ENG-PUDSP21001-R2-GEC-Redlines.pdf Markup Summary

Subject: SW - Comment
Page Index: 1
Date: 11/12/2021 2:07:59 PM
Author: dsdrice
Color: ■
Layer:
Space:
Page Label: 1

THE VILLAS AT CLAREMONT RANCH
PRE-DEVELOPMENT GRADING & EROSION CONTROL DETAIL SHEET

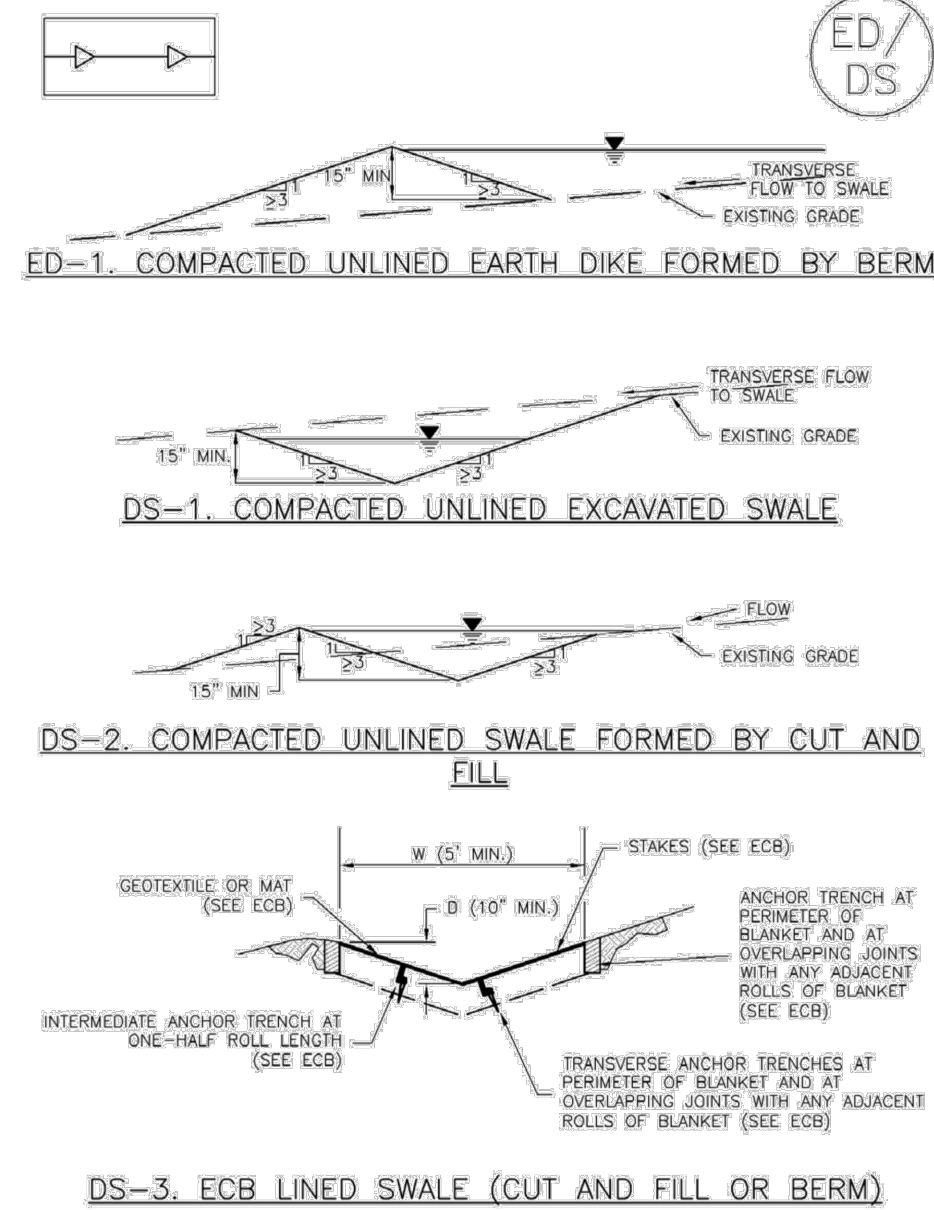
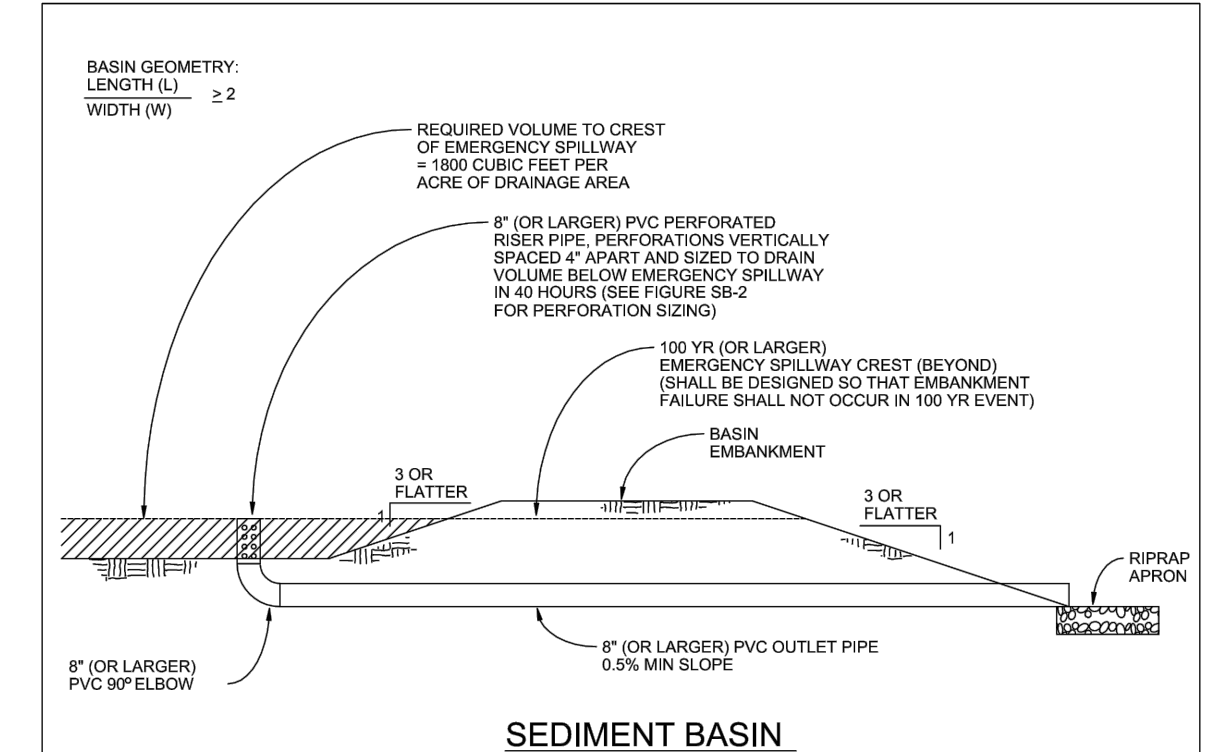
Address how spillway crosses the trail

Show and label existing swale

Label

How does this area drain?
